BRECKLAND DISTRICT COUNCIL

The Drovers Solar Farm (EN0110013)

Response to the Examining Authority's Second Written Questions (ExQ2)

Deadline 3 – 24 July 2026

Zone of Theoretical Visibility (ZTV)

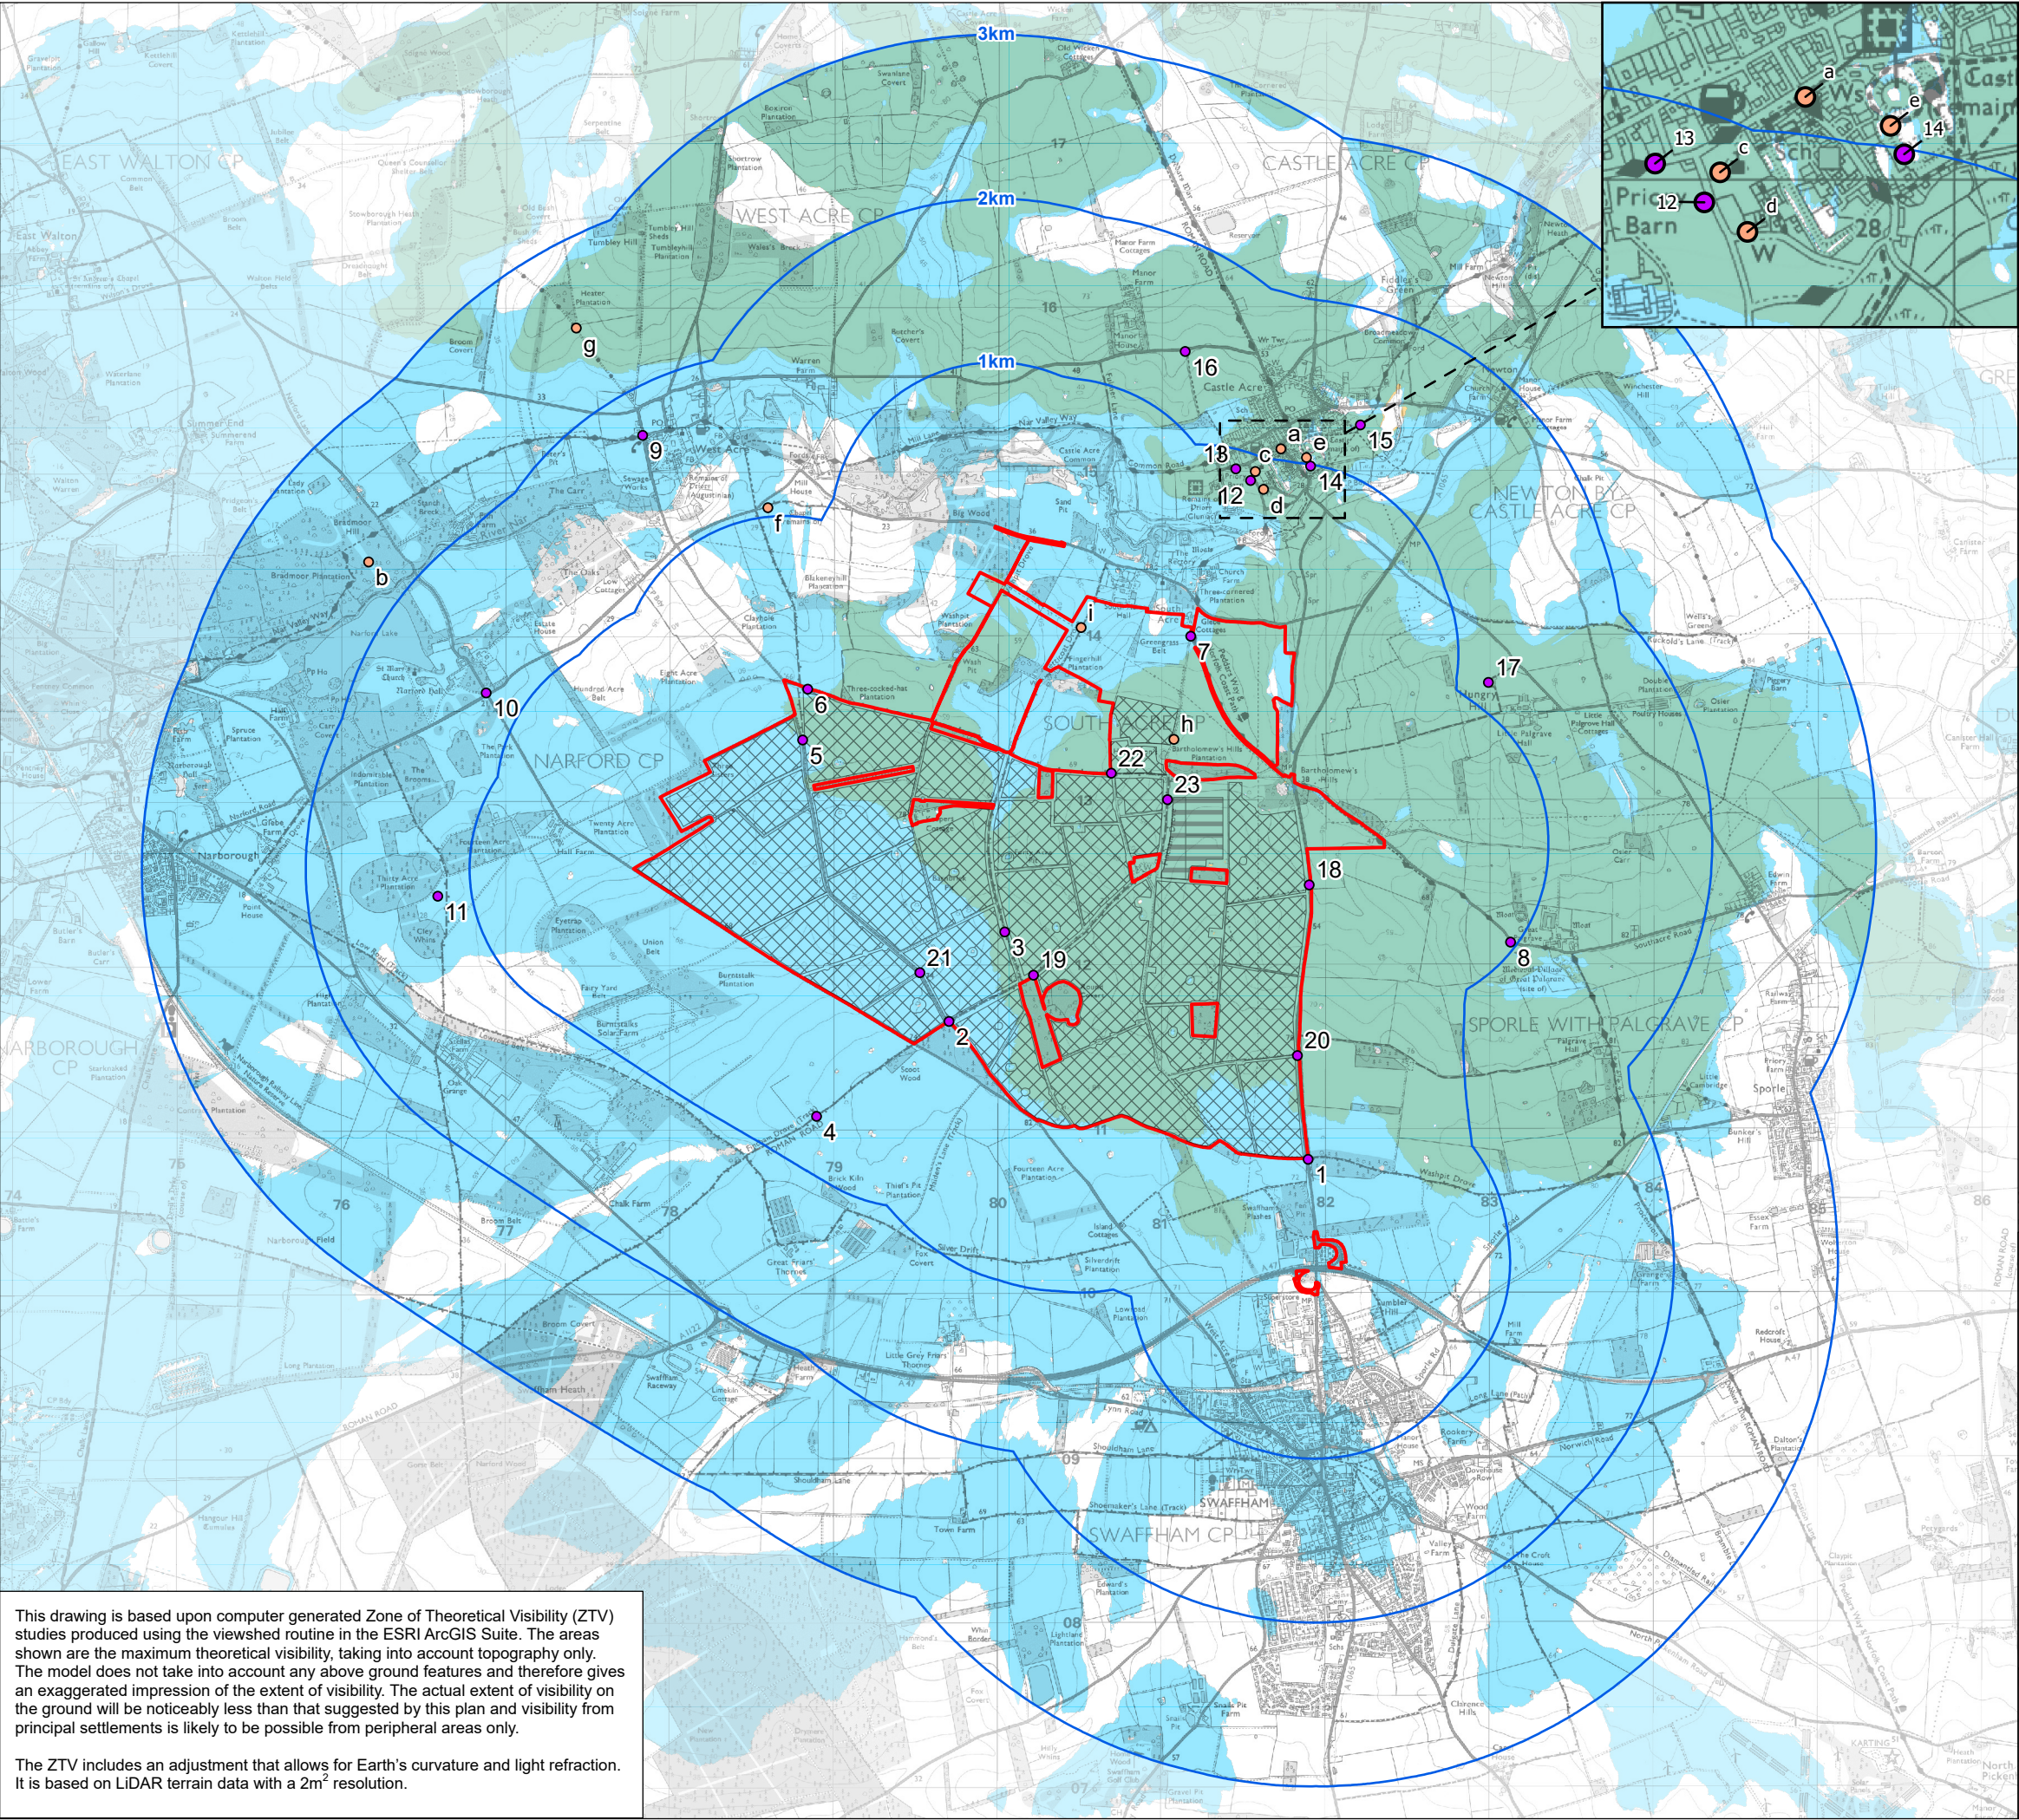
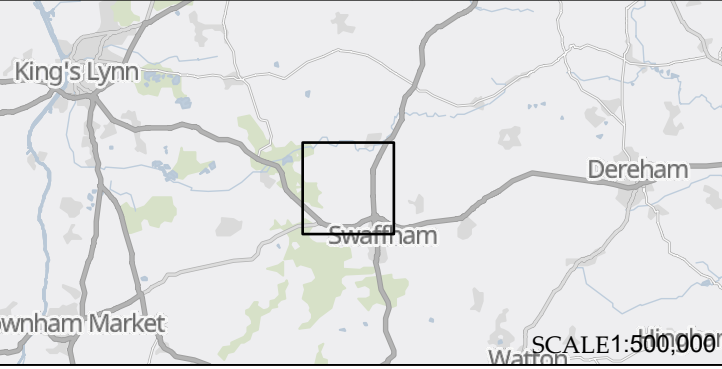
The Council considers that there should be an assessment of any areas where the Zone of Theoretical Visibility (ZTV) studies of proposed or existing solar farms intersect with the ZTV for the application site in order to assist in the assessment of cumulative visual effects.

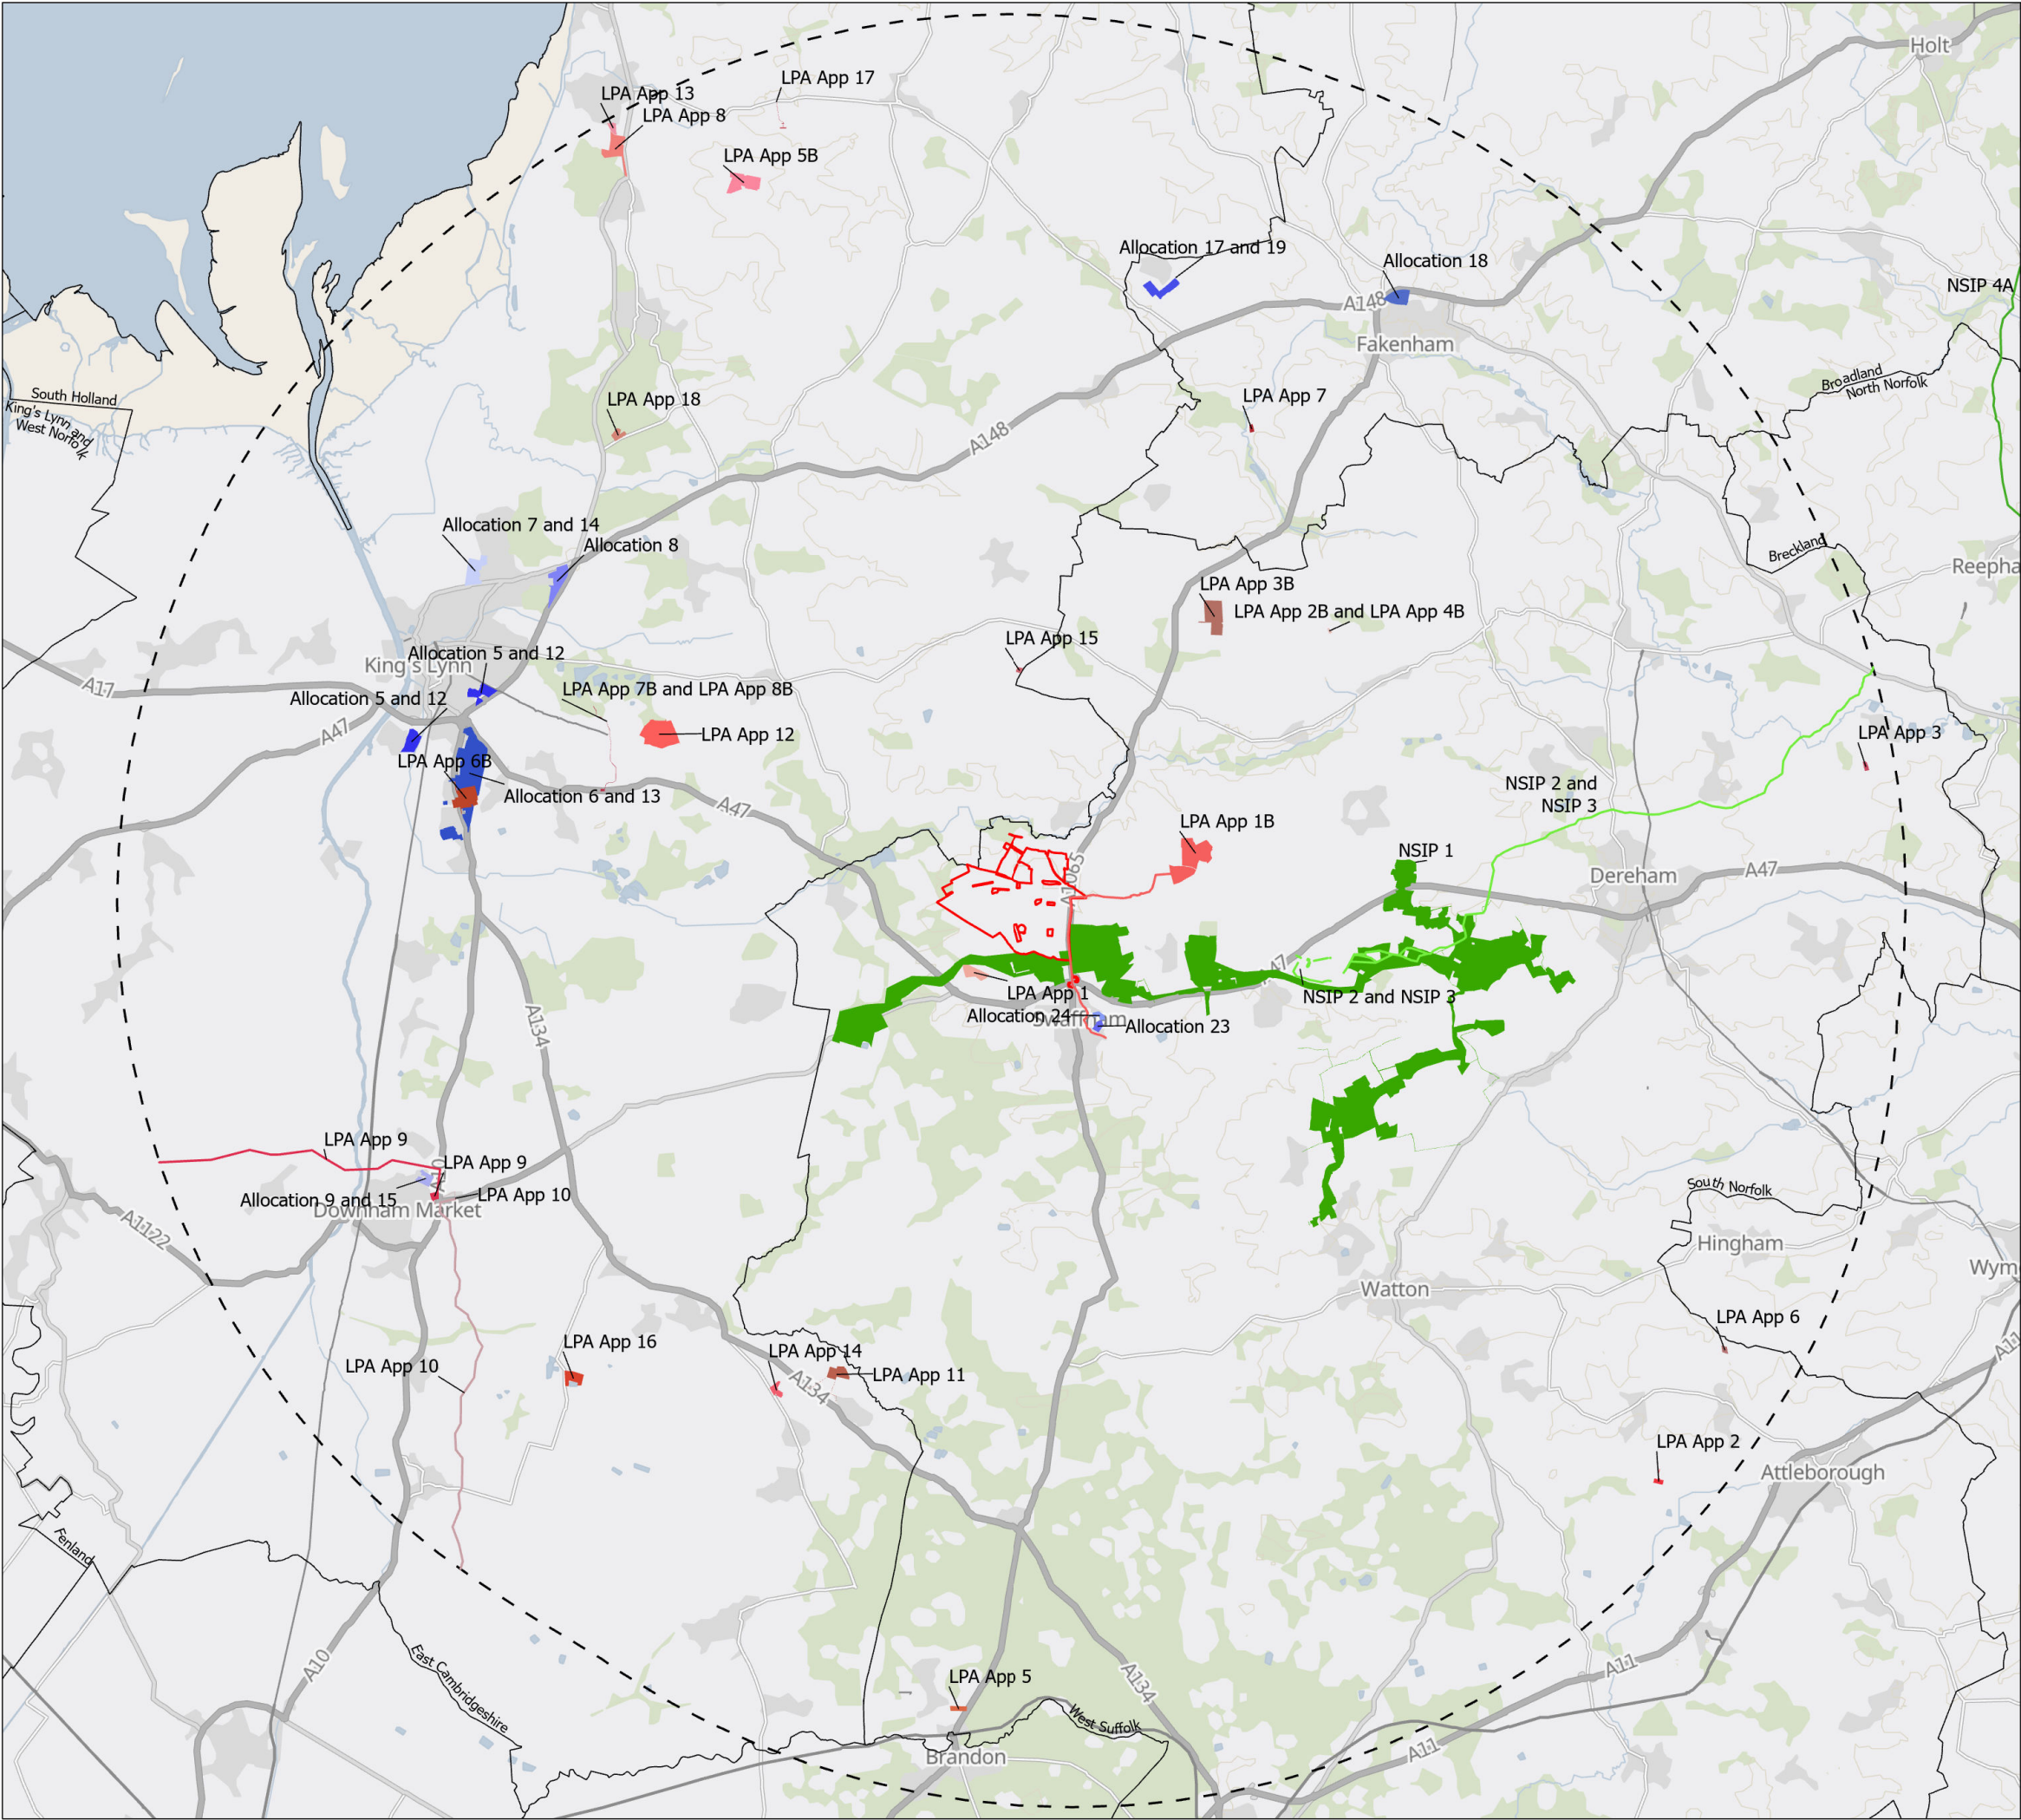
The Council remains concerned about the cumulative effects associated with energy infrastructure projects coming forward in Breckland and the wider area.

While existing and consented schemes are considered to be part of the baseline, the landscape only has so much capacity to absorb further developments of this nature before giving rise to significant adverse effects on a wider area. As such, developments of this nature, taken together with those already in existence, cumulatively affect the character of the area.

The Council considers that there should be an assessment of the cumulative effects of energy infrastructure in relation to the following Breckland Landscape Character Areas:

- D1 - Swaffham Heath; and
- E6 - North Pickenham Plateau

While the Council acknowledges that this is not the responsibility of the applicant for The Drovers, it wishes to draw the Inspector's attention to the many energy infrastructure projects that have been built/are coming forward in Breckland and the wider county area and its significant concerns regarding the cumulative effects on the landscape character and visual amenity within the area.
